Recommendation Report for Planning Permission for Works or Extension to a Dwelling

REF NO: R/261/19/HH

LOCATION: 3 Fosters Close
Rustington
BN16 2TL

PROPOSAL: Loft conversion from hip to gable end

Proposed South East Elevation

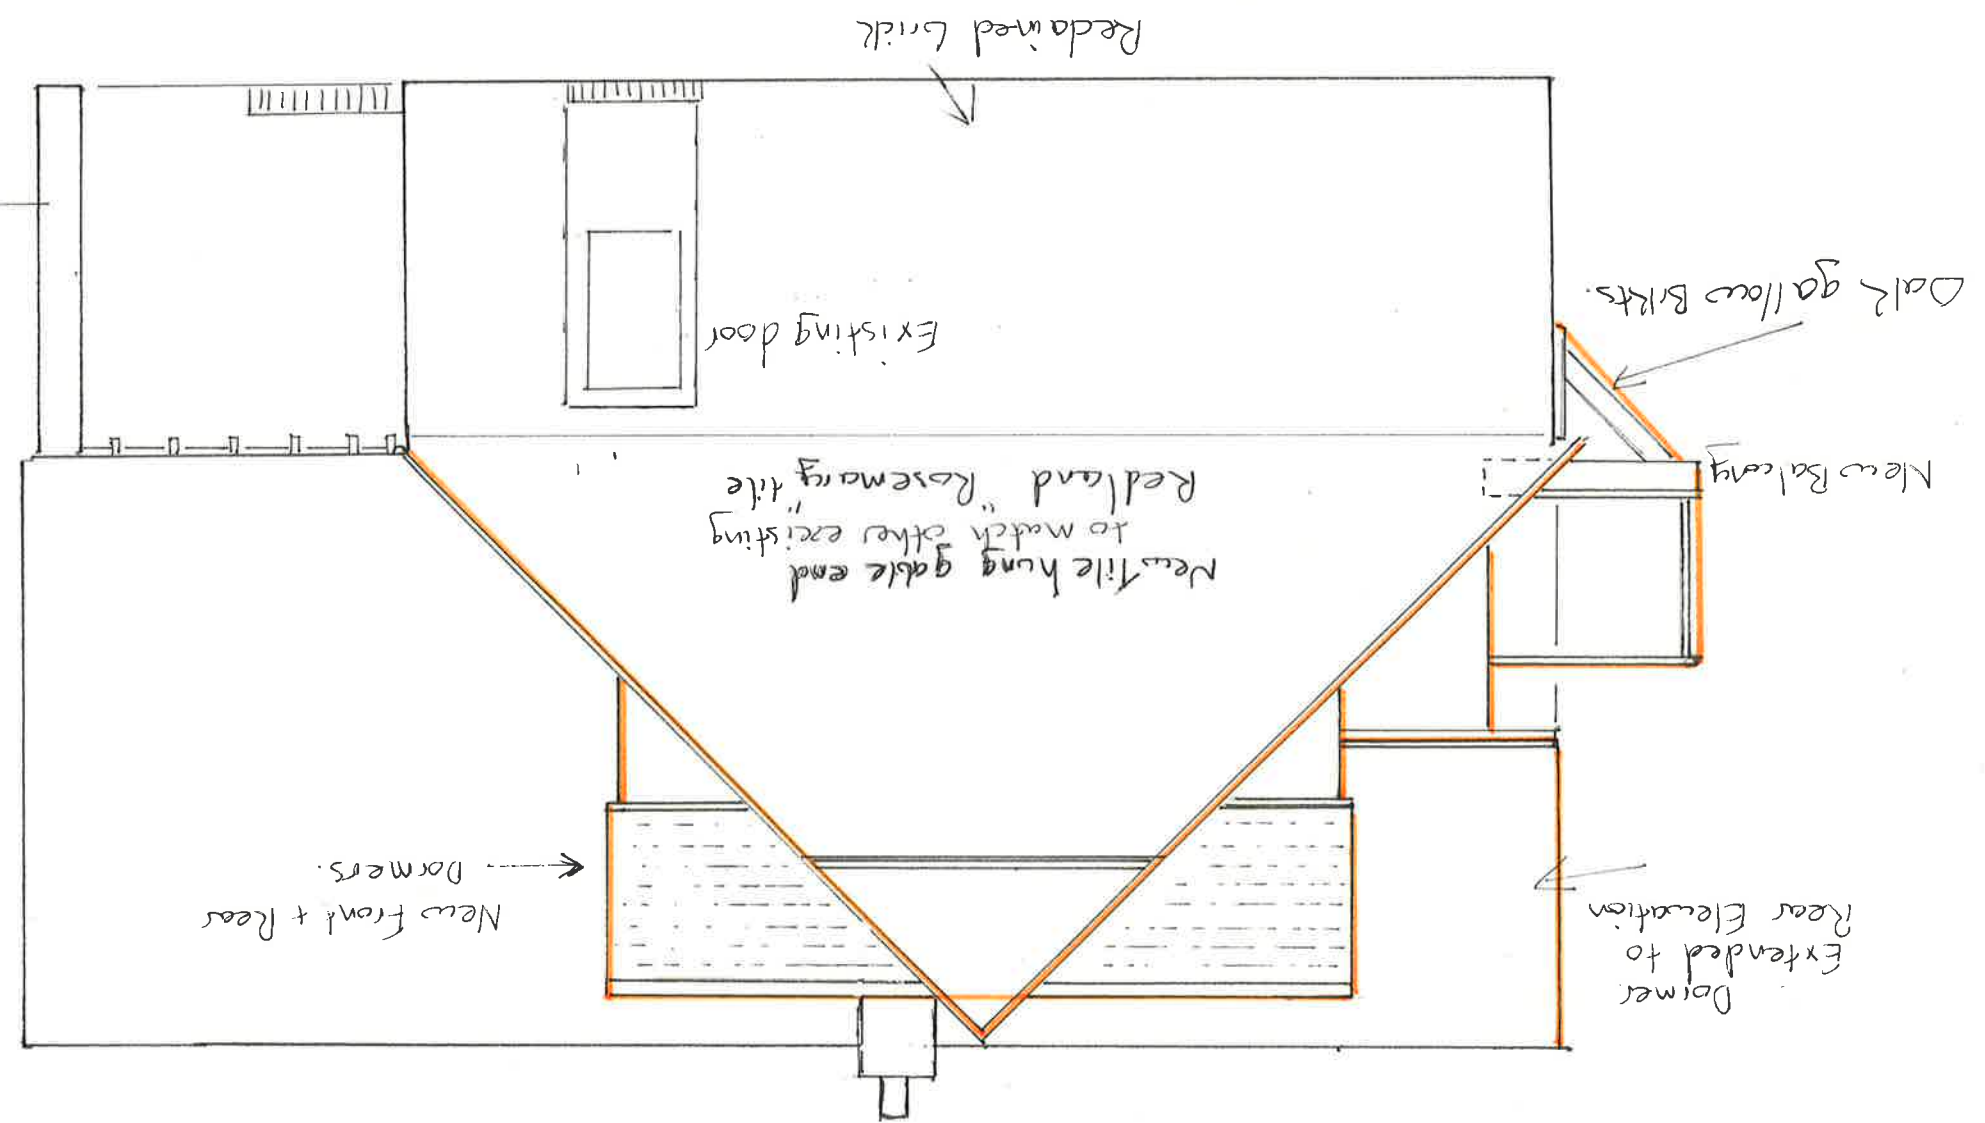
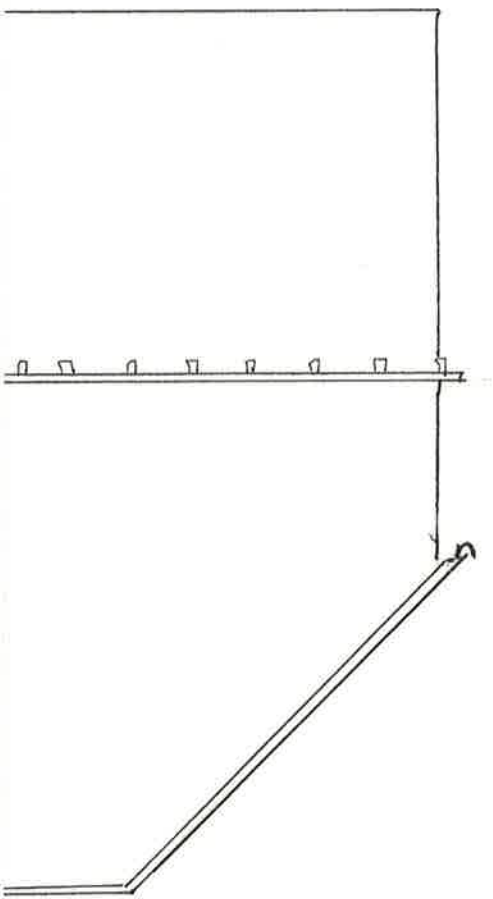
The proposed development is not considered to have an overbearing harmful impact upon the residential amenities of neighbouring dwellings. This is as a result of the siting of the proposed extensions, and the separation distance from neighbouring dwellings. To the South-East, the proposed development does not feature any 1st floor windows allowing harmful views to the neighbouring dwelling. With regard to overlooking the proposed balcony will allow for direct views of the adjacent dwellings private amenity area. Whilst it is noted that at current there is screening, in the form of hedging, this is not sufficient to prevent direct overlooking and as such, a condition will be recommended to ensure that obscure screening is installed on the North-Western and South-Eastern elevations of the balcony.

- 3 Prior to use of the balcony, 1.8m high obscure glazing panels shall be installed on the North-Western and South-Eastern elevations of the proposed balcony, and be retained in perpetuity.

Drawing R1

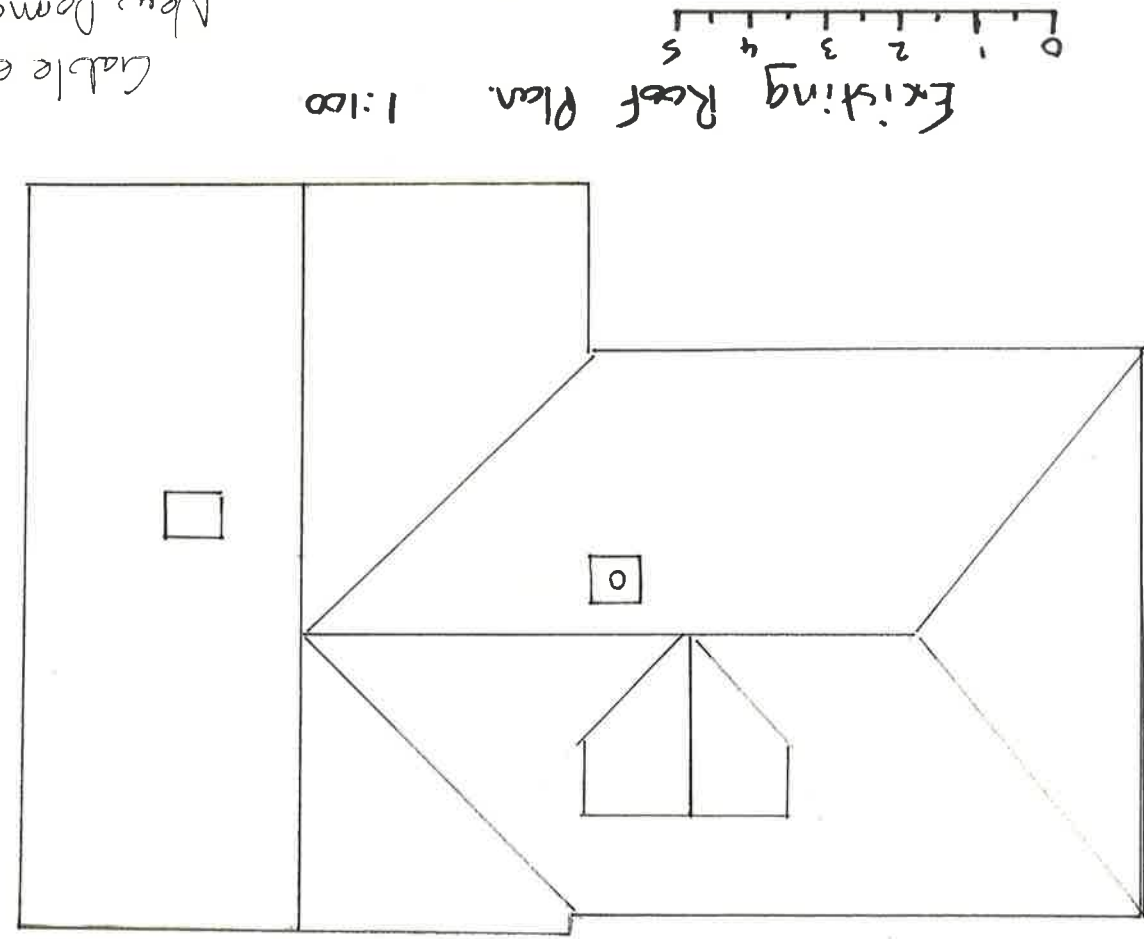
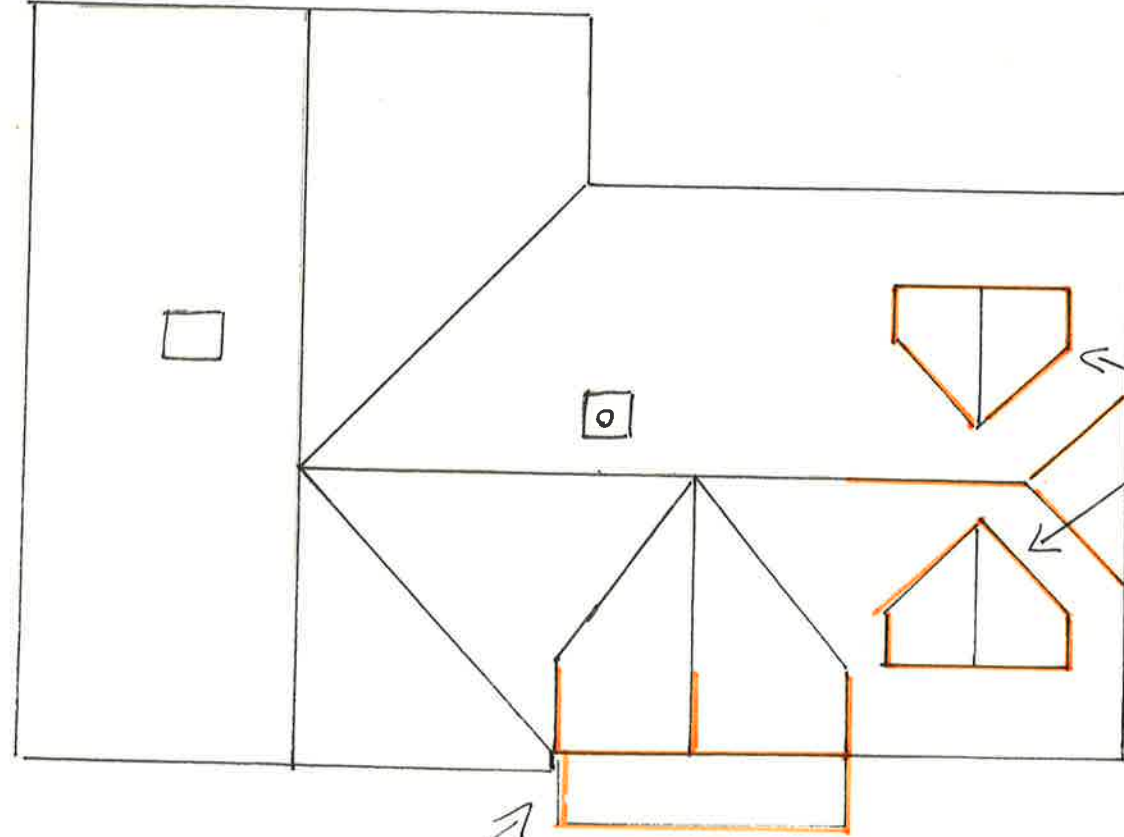
DESCRIPTION OF APPLICATION The proposed application seeks to construct a hip to gable extension to the South-Eastern roof slope. It also seeks to extend the rear dormer, and add a balcony to the rear elevation of the host dwelling.

The proposed development is not considered to have any significantly harmful impact upon the character of the host dwelling, or its immediate locality. This is due to the locality being host to a wide variety of dwelling styles, and designs. The proposed hip to gable extension is considered to be a sympathetic, and well integrated extension to the host dwelling, due to the proposed materials, and the modest design of the extension.
